25th November 2020

Town & Country Planning Act 1990 (as amended)
Town & country Planning (Development Management Procedure) (England) Order 2015 - Article 5

Application No: FP/212/20/OUT
Site Address: Pipers Croft 6 The Loop Felpham PO22 7ND
Description of works: Outline application with all matters reserved for 1 No. 4 bed detached dwelling.

Block Plan

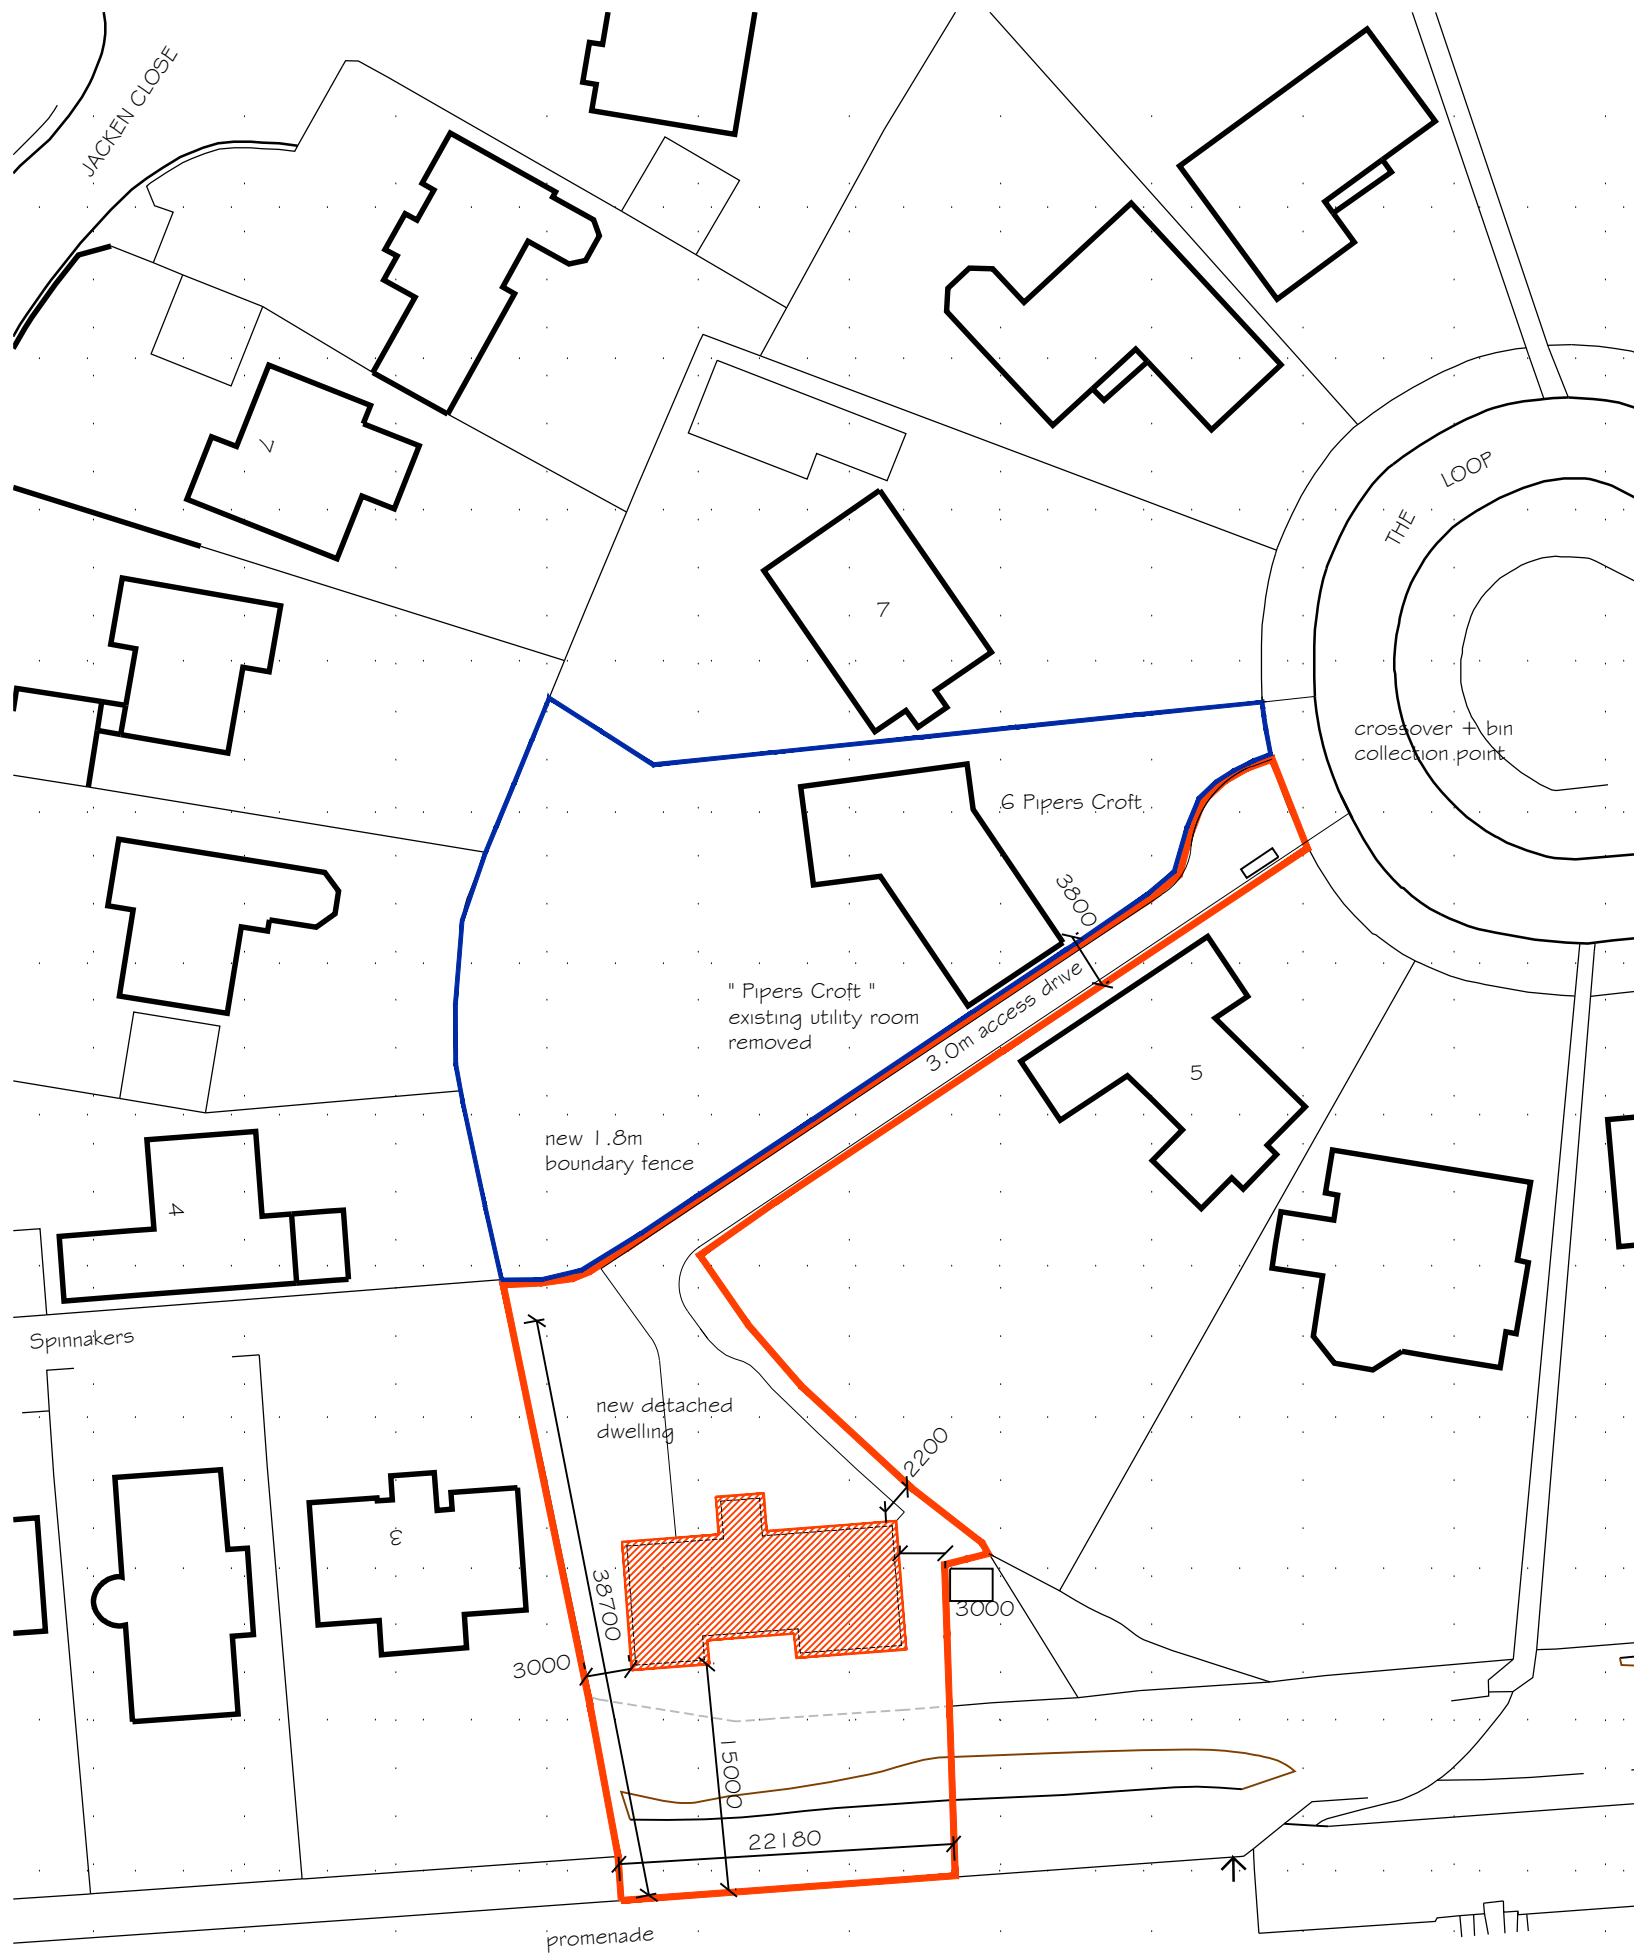
1. Overdevelopment, with an excessive footprint.
2. The proposal builds within the boundary of the pond ditch, an essential component of the water drainage system within the estate. This has historically been preserved to prevent flooding.
3. Trees that supported the local bird and bat life have recently been removed in order to ease the planning process. No provision appears to have been made to counter this.
4. The plans appear to suggest that the land extends beyond the existing fence line, to include the Sea defence bund. Can this be correct as removal of the bund would seem to be reckless?
5. No notice has been given to those of us directly attached in Jacken Close.
